**Development Review Board 1/17/07 Agenda Item #15
Sketch Plat: Lot 5, Block 2, Garcia Addition No. 3 and Lot
10, Block 2, Mariposa Addition**

**CITY OF ALBUQUERQUE
PLANNING DEPARTMENT
January 17, 2007
DRB Comments**

PROJECT # 1005316

**RE: Lot 5, Bk 2, Garcia Addition & Lot 10, bk 2, Mariposa
Add/sketch**

SKETCH PLAT OF
 LOT 5, BLOCK 2, GARCIA ADDITION &
 LOT 10, BLOCK 2, MARIPOSA ADDITION
 SECTION 29, T. 10 N. R. 3 E., N.M.P.M.
 BERNALILLO COUNTY, NEW MEXICO
 DECEMBER 2006

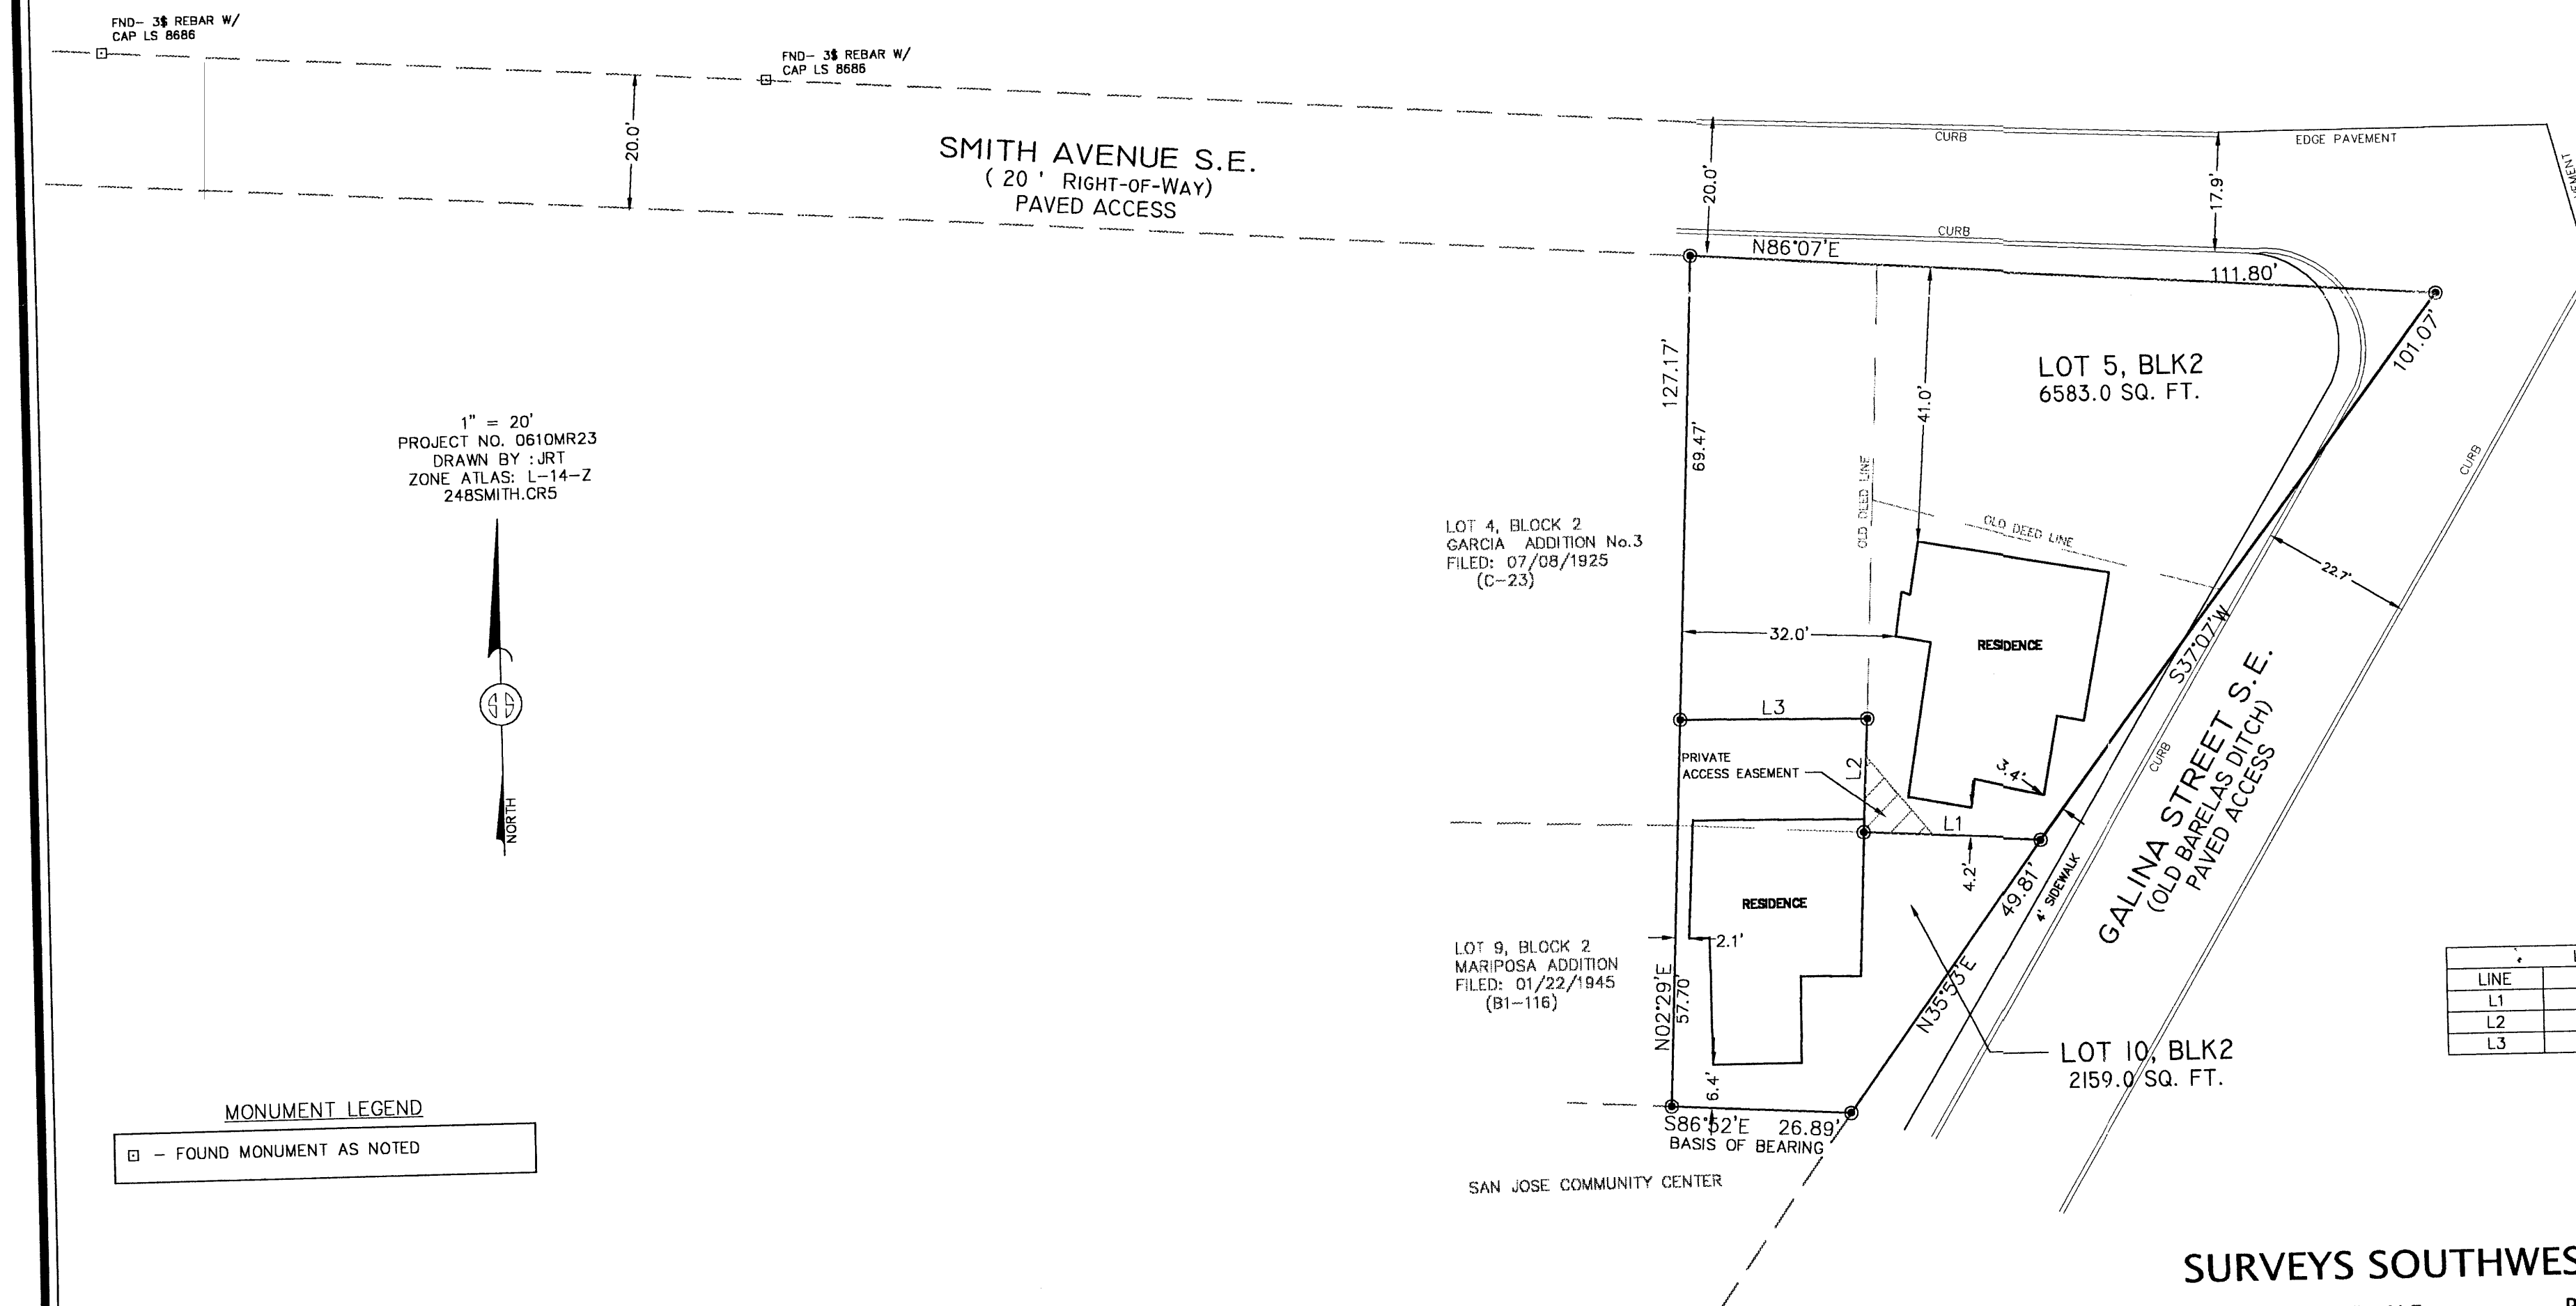
Make sure that the setbacks apply from the R-1 zone, as well as minimum lot size requirements are met. A special exception (variance) request may be required.
